DRB Project Number: 1006697
Loop Industrial District

SUBJECT: Site Plan for Building Permit

DRB Project No: 1006697	Date: 05/09/2018	Item No: #2
Zone Atlas Page: C-17	Legal Description: Tract(s) D-1A1-B, LOOP INDUSTRIAL DISTRICT Location: on WILSHIRE AVE NE west of SAN MATEO BLVD NE and east of JEFFERSON ST NE	
Request For: 18DRB-70103 MAJOR – SITE DEVELOPMENT PLAN FOR BUILDING PERMIT

Project Name: Silver Star Auto Haus

1 EAST ELEVATION  
SCALE: 1/8" = 1'-0"

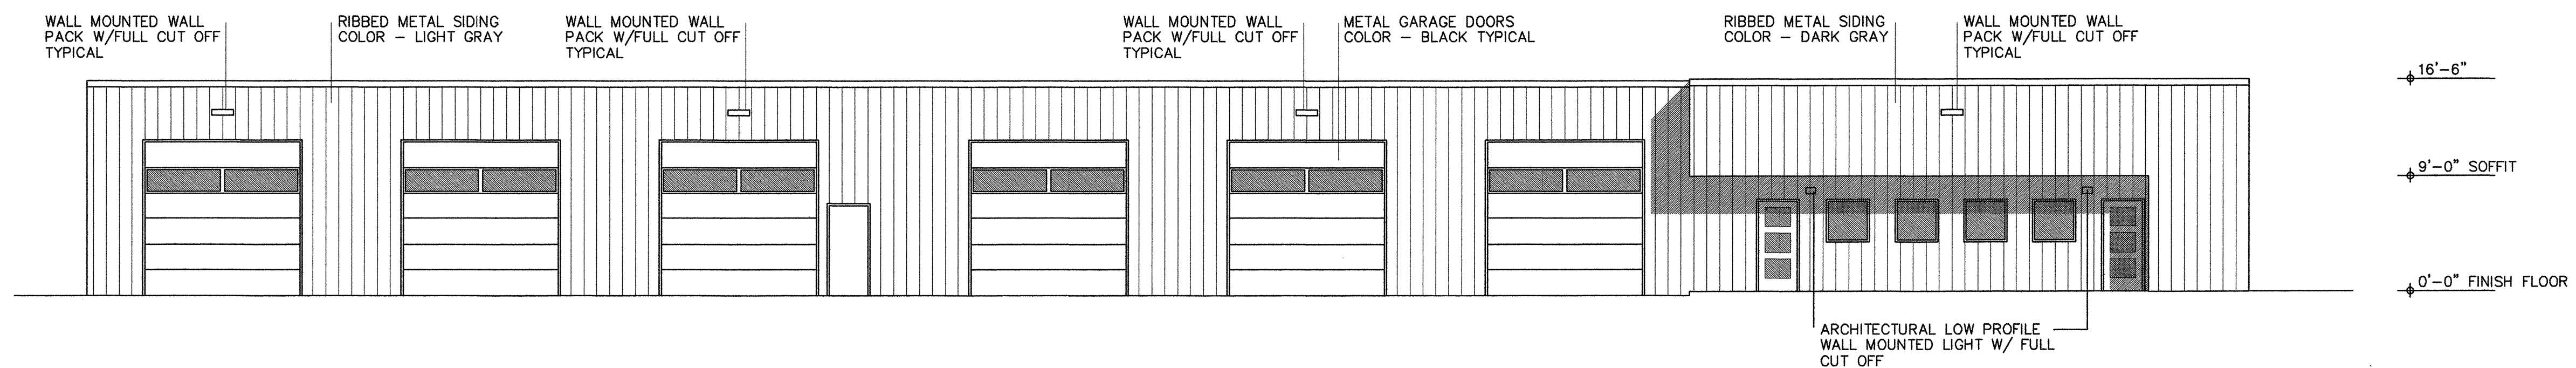
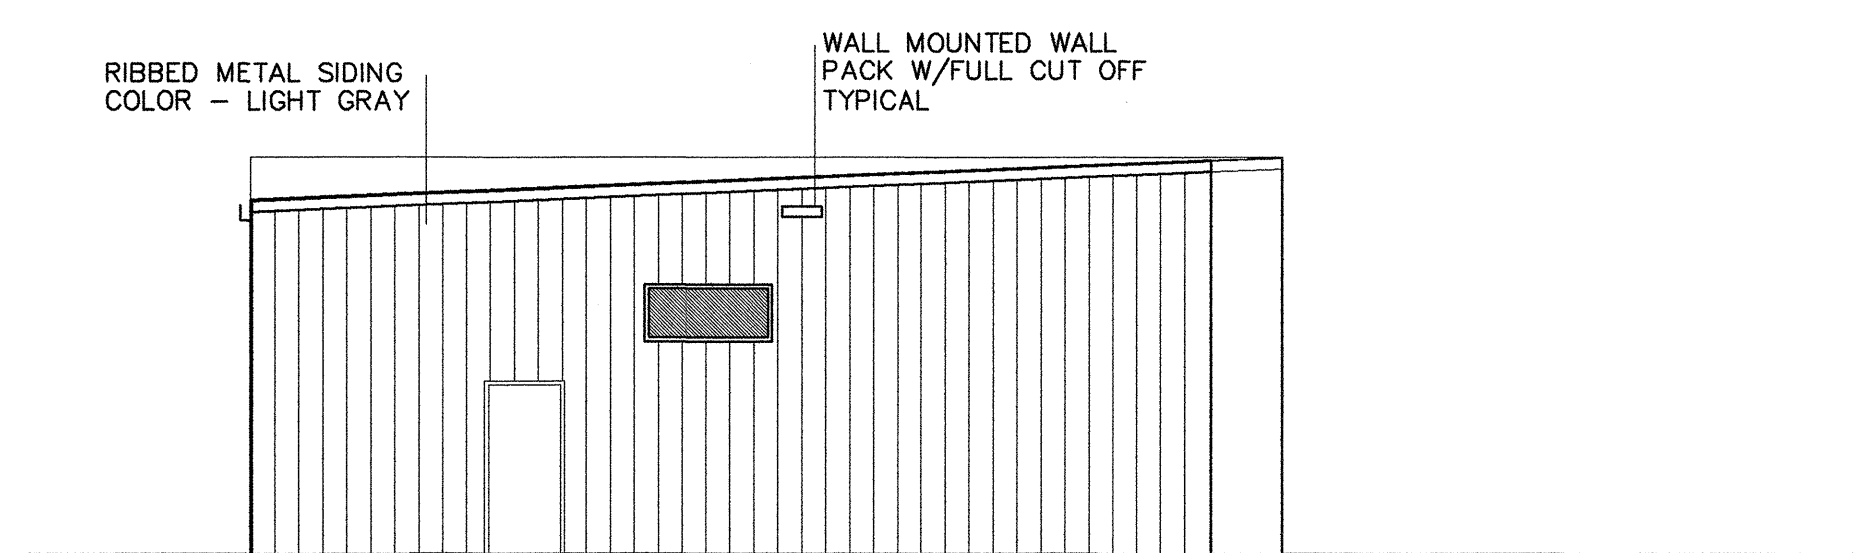
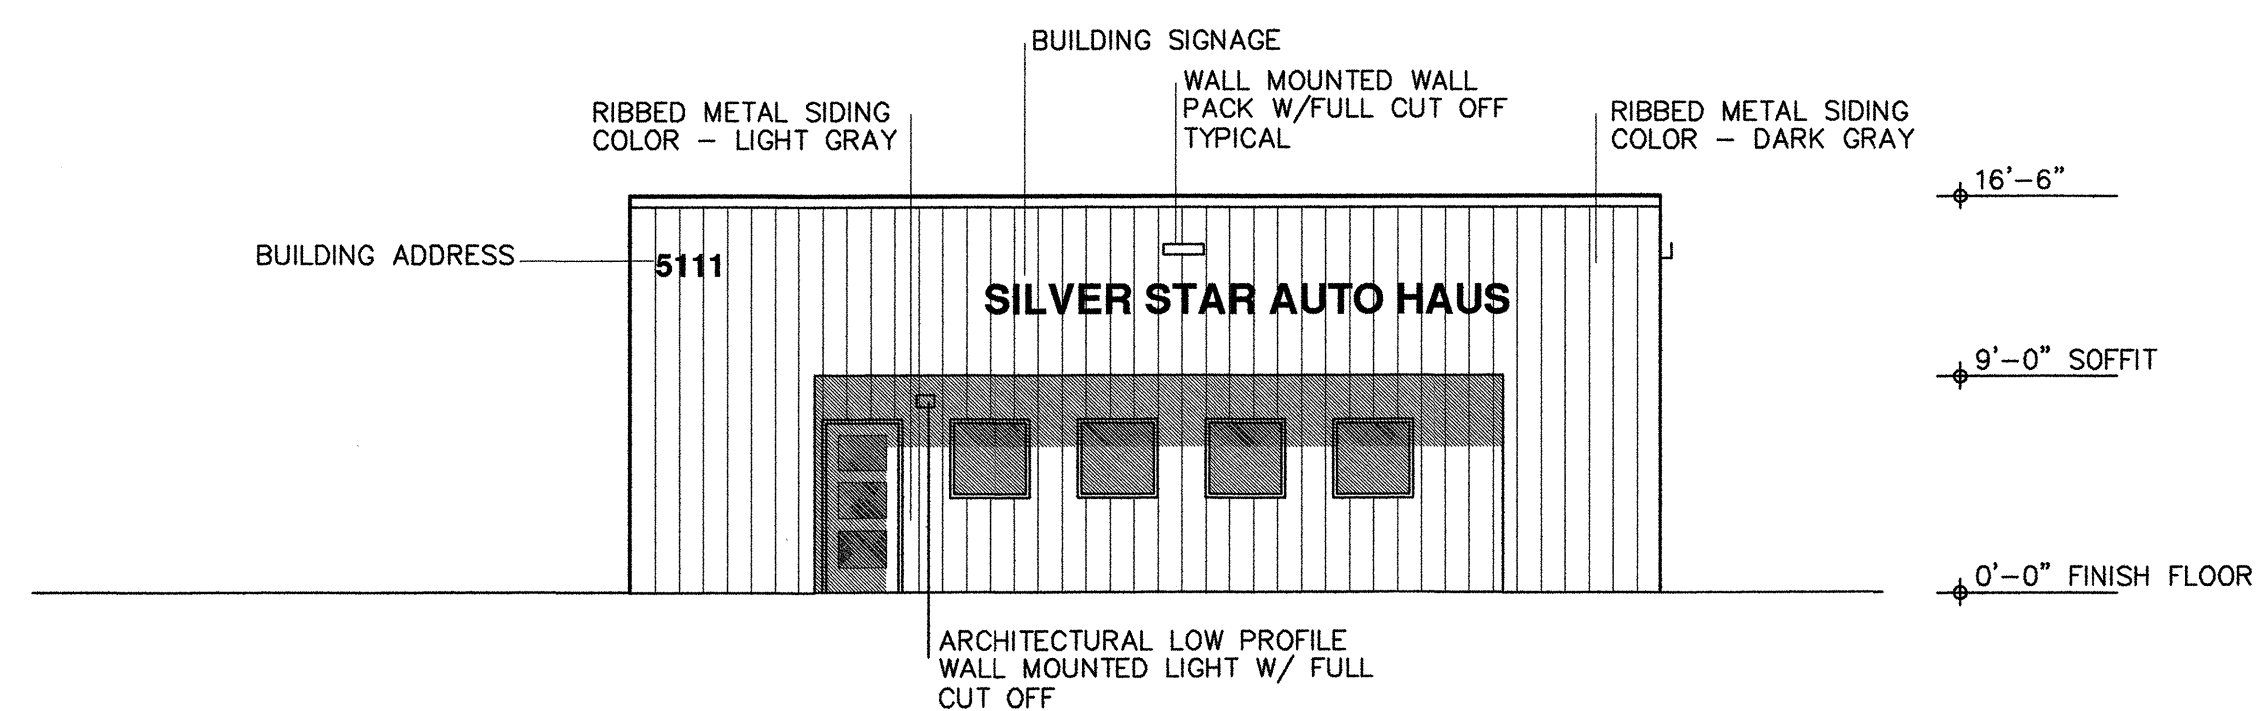
7. A minimum 6 foot landscaped strip shall be maintained between parking areas and adjacent lots. Must be called out/dimension on LSP. **DONE**
8. Facades with a length of 100 feet or more shall incorporate wall plane projections or recesses having a depth of at least 3 feet and extending at least 20% of façade. **How does the eastern façade meet this requirement? (B (4) page 36) Still needs to be addressed.**

10. Building facades require a minimum of 2 different finishes. How has this been addressed on the building facades? (D (1)) **How has this been addressed on the eastfaçade?**

5. Floodlights must not exceed 75 watts and must be mounted between 6 and 14 feet above the grade. Add note to building elevation sheet and make sure to dimension the location of the lights shown currently on the facades. **DONE**

SITE PLAN

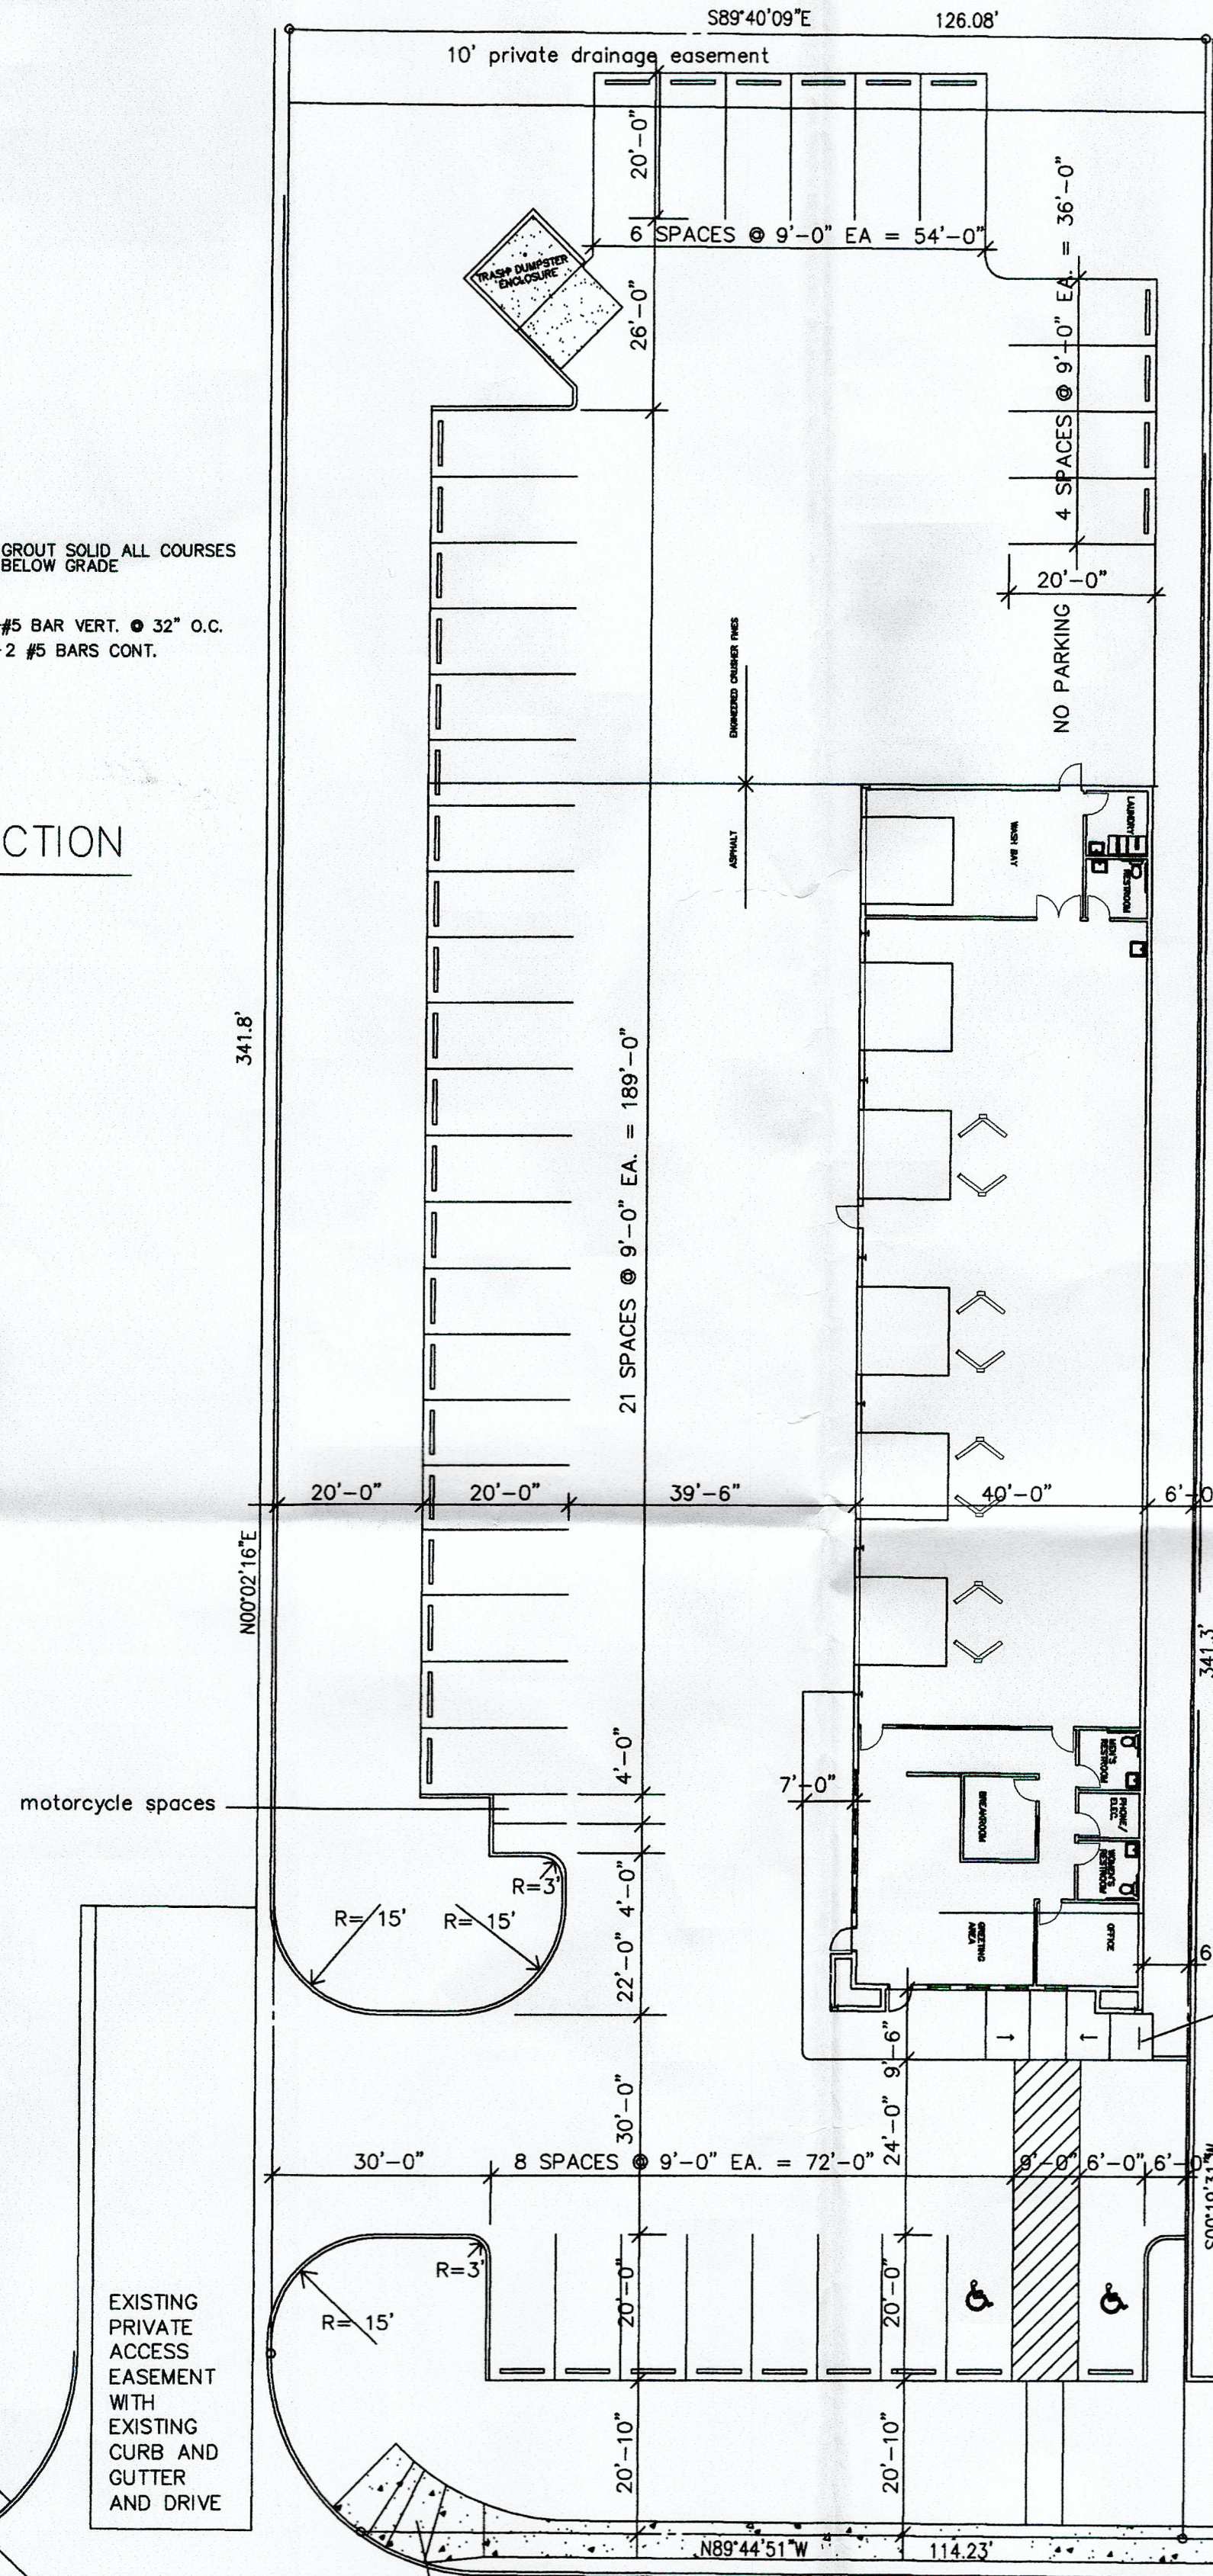
2. Distinguish pedestrian surfaces or key pedestrian way from driving surfaces through the use of special materials such as special pavers, bricks or scored concrete to enhance pedestrian safety (page 32). Label the material on the site plan. Currently it just looks like painted striping. **DONE**

3. Looks like there is a pedestrian connection from the parking lot to the public sidewalk but it is not labelled or dimensioned. **DONE**
4. Sidewalk is to be provided along the full length of the building along any façade featuring an entrance. It appears this has been met but there is no labelling. **DONE**
